From: Andrew Wood
Sent: 14 January 2019 12:59
To: Karen Parsons
Subject: FW: FP/188/18/HH - 68 Limmer Lane - Extension of Time Request
Attachments: 68 Limer Lane New Elevations 3 Revised.PDF

FP/188/18/HH - 68 Limmer Lane - Extension of Time Request

Drawing 3 / 4

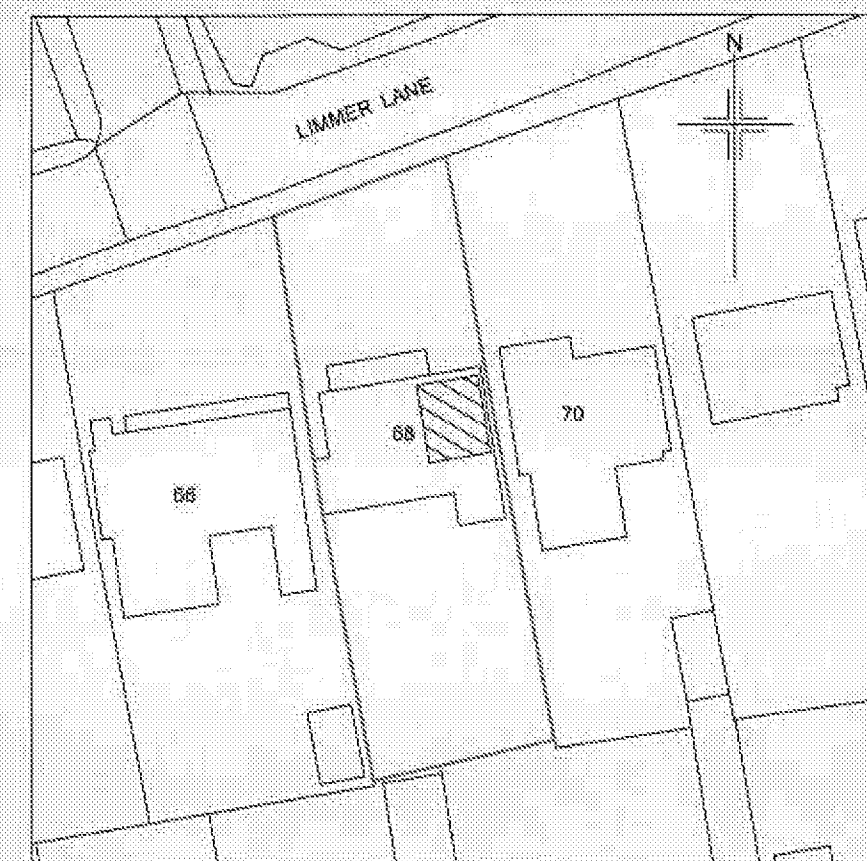
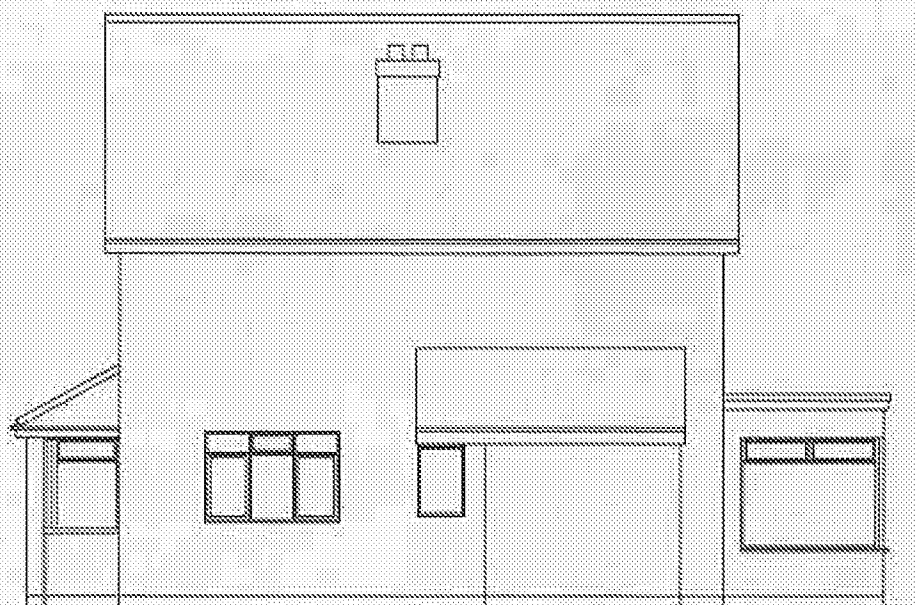
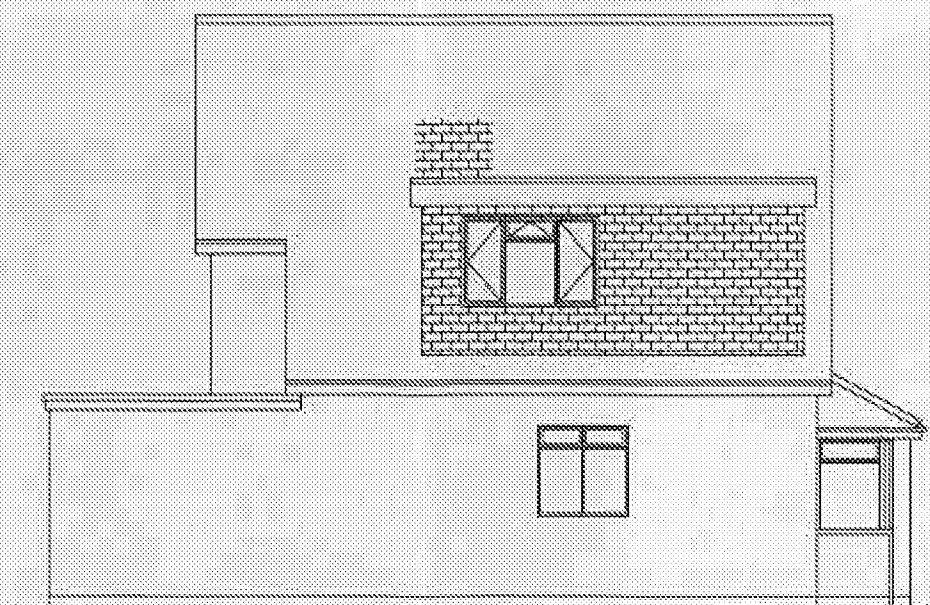
I agree to the extension of time to the 1st of February 2019 and attach revised new elevation plan replacing the tiles with half timber and plaster to the dormer to match the front gable.
